**WELWYN HATFIELD BOROUGH COUNCIL
EXECUTIVE DIRECTOR - PLANNING, PUBLIC PROTECTION AND GOVERNANCE**

Application No: 6/2021/1172/LAWP
Location: Colesdale Farmhouse Northaw Road West Northaw Potters Bar EN6 4QZ
Proposal: Certificate of lawfulness for the demolition of historical rear two storey extension, and erection of a two storey rear extension projecting off the original rear wall with rooflights installed to the side and rear roof pitches.
Officer: Ms Emily Stainer
Recommendation: Refused

6/2021/1172/LAWP

**SK-006**

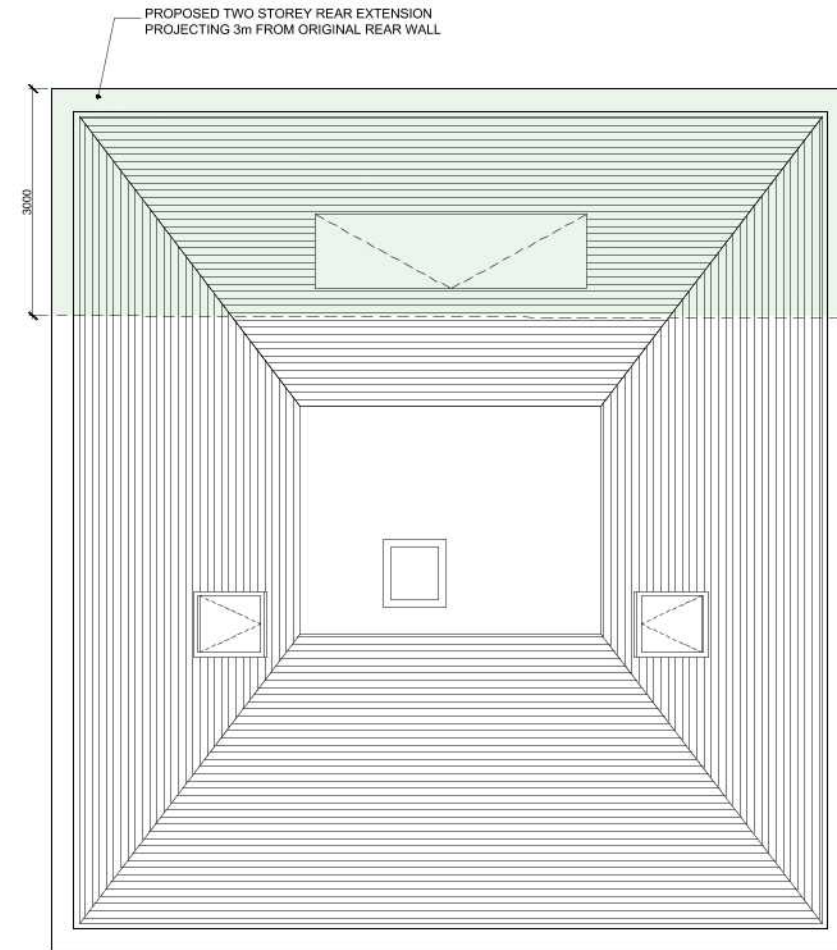
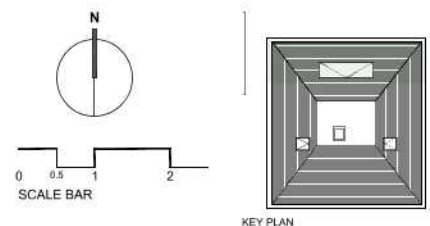
(c) where the enlarged part of the dwellinghouse has more than a single storey, or forms an upper storey on an existing enlargement of the original dwellinghouse, the roof pitch of the enlarged part must, so far as practicable, be the same as the roof pitch of the original dwellinghouse.	Y	Y
Discussion		
<p>Class A.1 (k) (iv) says that Class A does not apply if the works consist of or include an alteration to any part of the roof of the dwellinghouse. Whilst it is often interpreted that non-compliance with A.1(k)(iv) does not prevent the whole of the extension from being permitted development, it does require the extension to the roof to be assessed against Classes B and/or C of Part 1, Schedule 2. The Technical Guidance Document (2019) supports this view, stating that <i>“When considering whether a development proposal is permitted development, all of the relevant Parts of the Order and all the Classes within those Parts need to be taken into account.”</i> Class B permitted development rights relate to <i>‘the enlargement of a house consisting of an addition or alteration to its roof’</i>. Therefore, as the proposed two storey rear extension would enlarge the roof of the existing dwelling, it is considered Class B is also relevant in the determination of this element of the application. Furthermore, rooflights are proposed in the roof slope, so Class C will apply. These are discussed in more detail below.</p>

(c) would it result in the highest part of the alteration being higher than the highest part of the original roof; or	N	N
(d) would it consist of or include— (i) the installation, alteration or replacement of a chimney, flue or soil and vent pipe, or (ii) the installation, alteration or replacement of solar photovoltaics or solar thermal equipment.	N N	N
Conditions		
C.2 Development is permitted by Class C subject to the condition that any window located on a roof slope forming a side elevation of the dwellinghouse must be— (a) obscure-glazed; and (b) non-opening unless the parts of the window which can be opened are more than 1.7 metres above the floor of the room in which the window is installed.	<u>N</u>	Y
Discussion and Conclusion		
<p><u>Side Windows/Rooflights</u></p> <p>Three upper floor rooflights and a recessed dormer are proposed in the roof slope of the property. The conditions and limitations under Class A, B and C refer to upper floor side windows, noting that <i>“any window inserted/located on a wall or roof slope forming a side elevation of the dwellinghouse”</i> must be obscure glazed and non-opening unless the parts of the window which can be opened are more than 1.7 metres above the floor of the room in which the window is installed. The supporting information does not indicate if the proposed rooflights/side windows would be obscure glazed or fixed, nor does it demonstrate how high above the floor level they would be. In the absence of this information it is not considered the proposed windows would comply with the conditions and limitations of Schedule 2, Part 1, Class A.3 (b) (i) or (ii), Class B.2 (c) (i) or (ii) and Class C.2 (a) or (b) of the General Permitted Development Order 2015 (as amended).</p> <p>Furthermore, the information submitted does not detail if the proposed materials of the extension and alterations would match the existing property under Schedule 2, Part 1, Class A, A.3(a) or Part 1, Class B, B.2 (a) of the Town and Country Planning (General Permitted Development) (England) Order 2015 as amended. The proposal is therefore not permitted development and planning permission will be required. On this basis the application is recommended for refusal.</p>

2. Insufficient information has been provided to demonstrate that the proposed development complies with the conditions and limitations of Schedule 2, Part 1, Class A.3 (b) (i) or (ii), Class B.2 (c) (i) or (ii) and Class C.2 (a) or (b) of the General Permitted Development Order 2015 (as amended).

DWG. NO.
SK-007

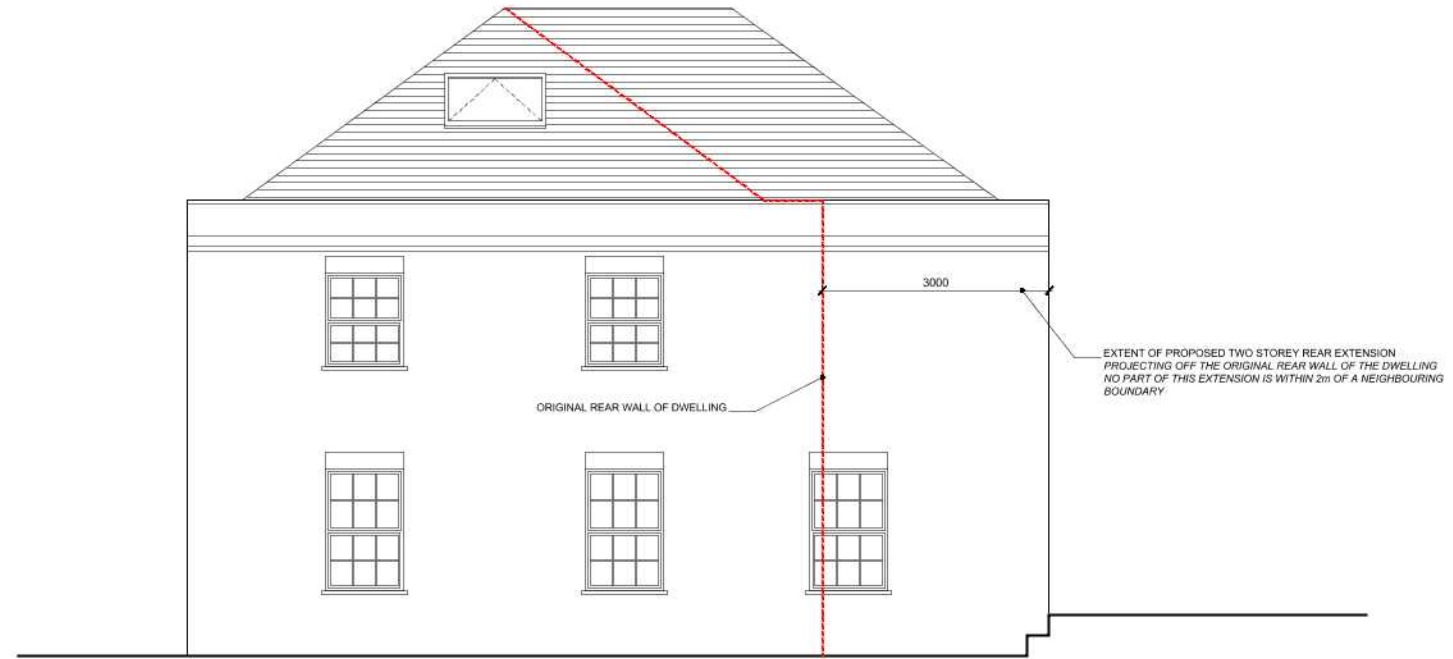
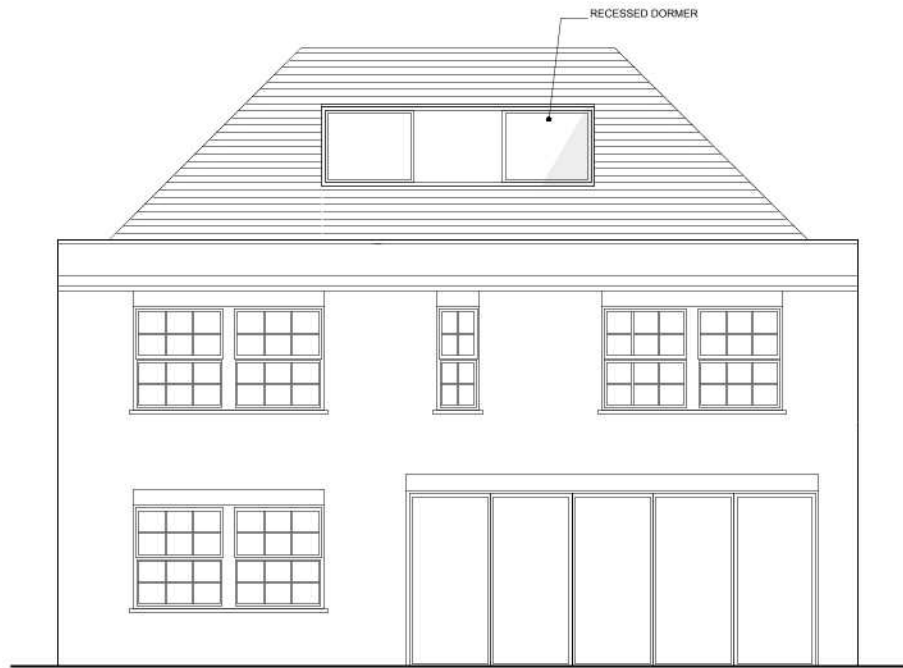
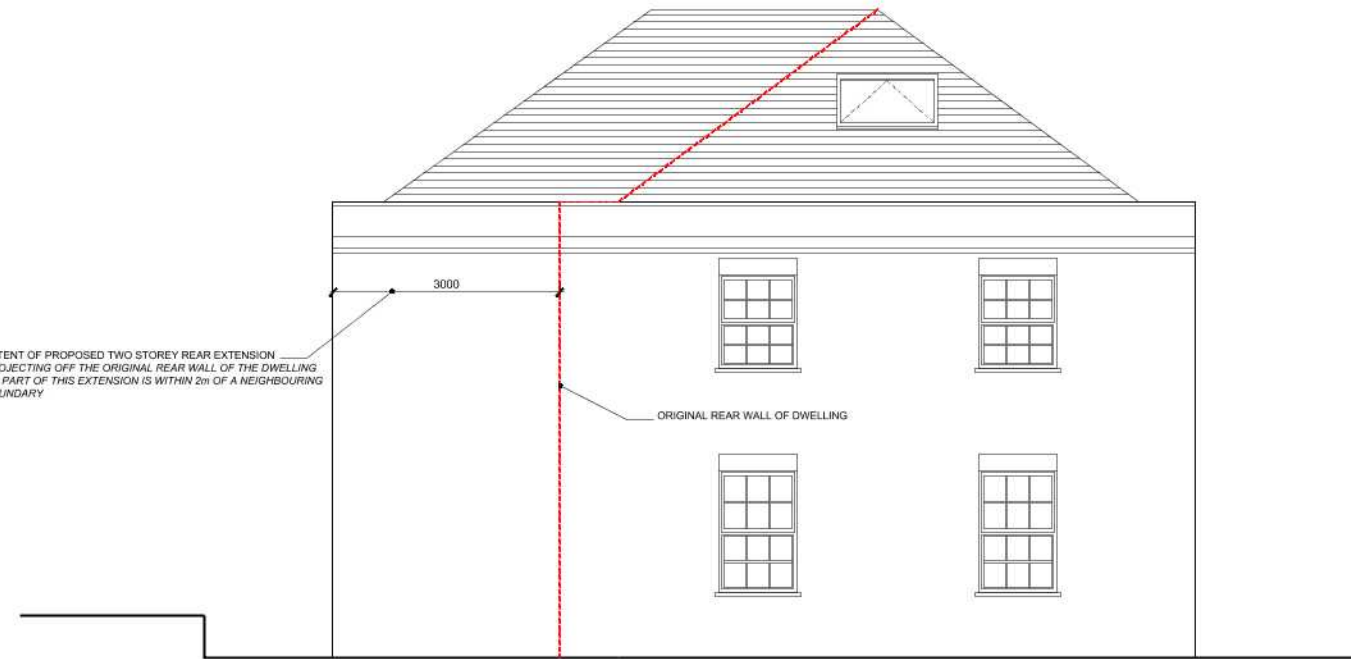
1. Insufficient information has been provided to demonstrate that the proposed development complies with Schedule 2, Part 1, Class A, A.3(a) or Part 1, Class B, B.2 (a) of the Town and Country Planning (General Permitted Development) (England) Order 2015 as amended.
